Waddington Parish Council

30th December 2020

Application reference: 3/2020/0932

proposed elevations 1:100

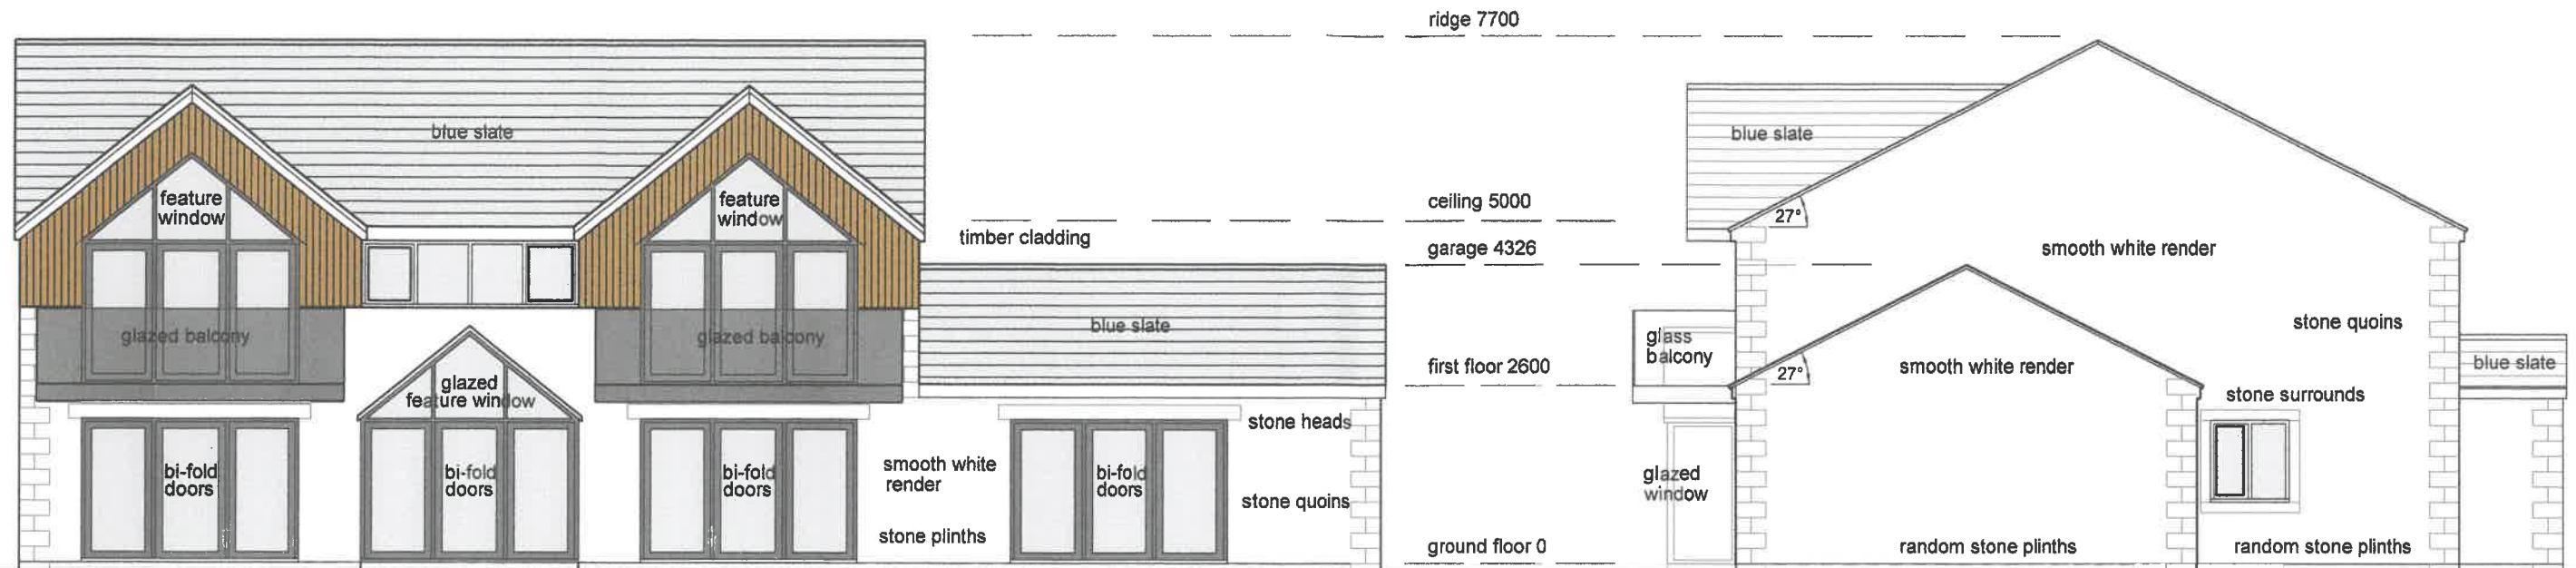
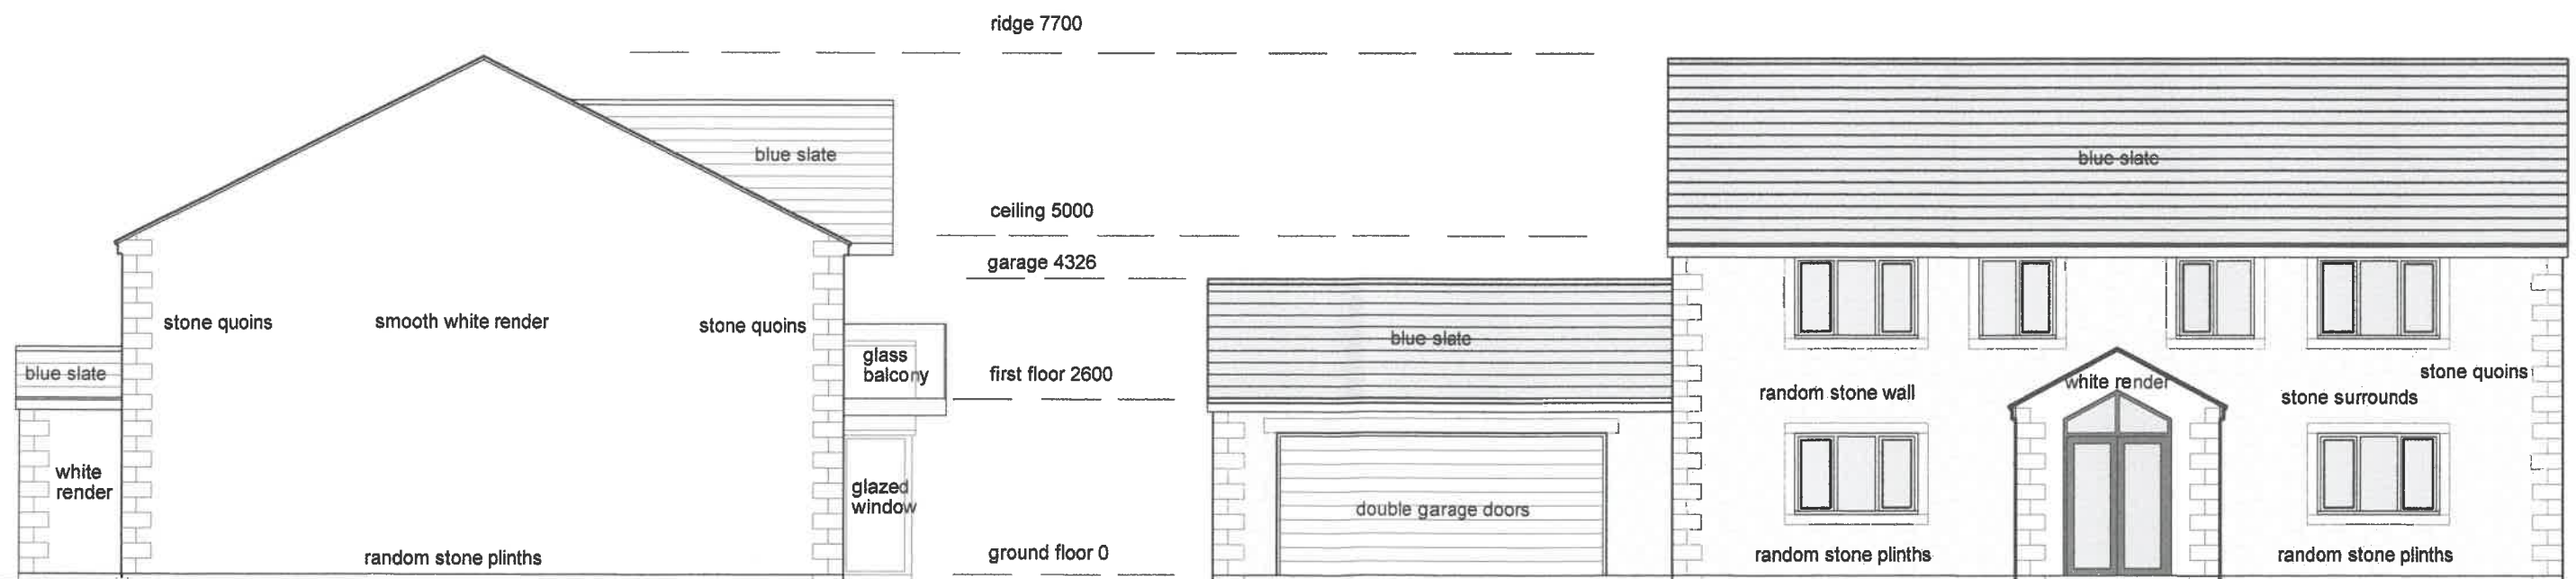
If Ribble Valley Borough Council intends to grant permission for the above planning application, I urge you to make installation of six swift nest bricks a planning condition, providing a minimum of three nest bricks to each gable end of the new building.

I enclose an annex which lists a range of possible solutions, products and resources, including boxes to suit an external rendered finish as proposed.
